From: Graham Evans
Sent: 13 May 2009 16:16
To: Planning.Responses
Subject: FW: Planning Consultation on: R/79/09/

Food Safety Officer Comment:-

APPLICATION NO: R/79/09/

Description of Works: Demolition of existing playgroup building and erection of replacement playgroup building.

PROPOSED PLAN LAYOUT

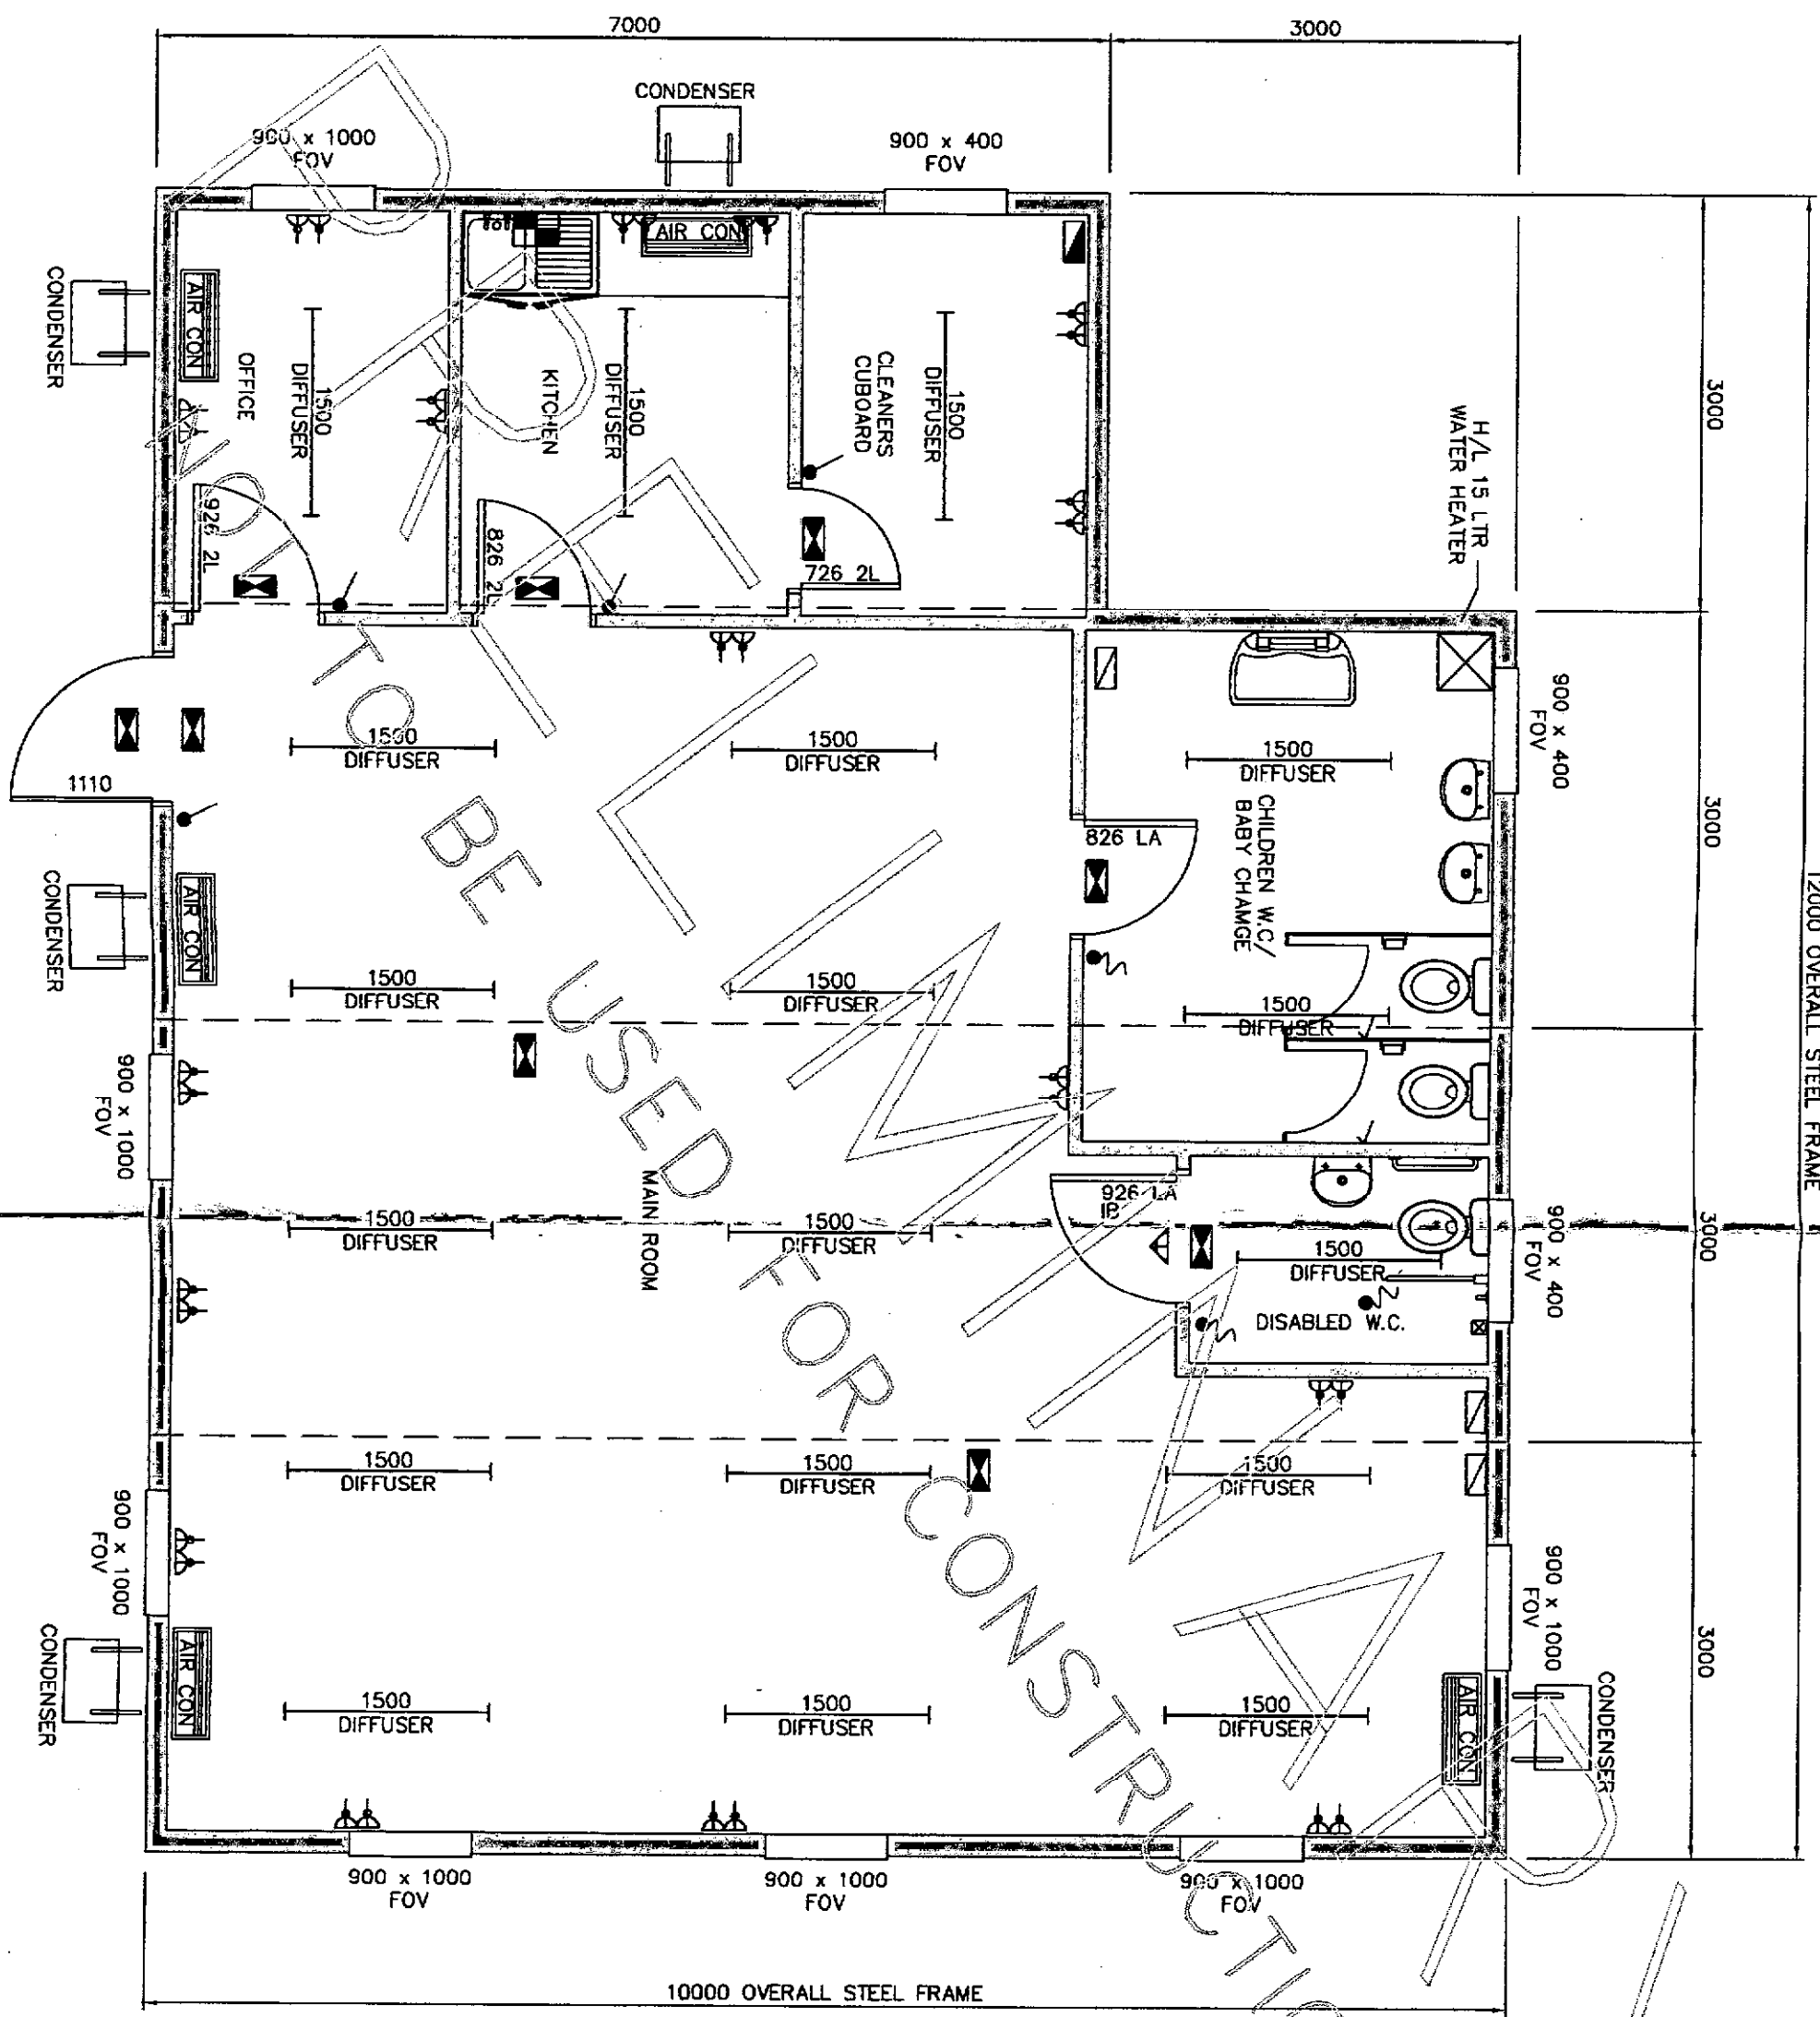
Examined history of inspections, no previous food preparation activities noted during visits. Proposed kitchen is very small, which does not permit large scale catering for high risk groups. However, may be sufficient for low risk activities, not involving cooking of hot meals for young children. The applicant should consider providing sufficient capacity for the storage of children's packed lunches, if susceptible foods are included. Any contraventions of this nature will be dealt with under food safety legislation.
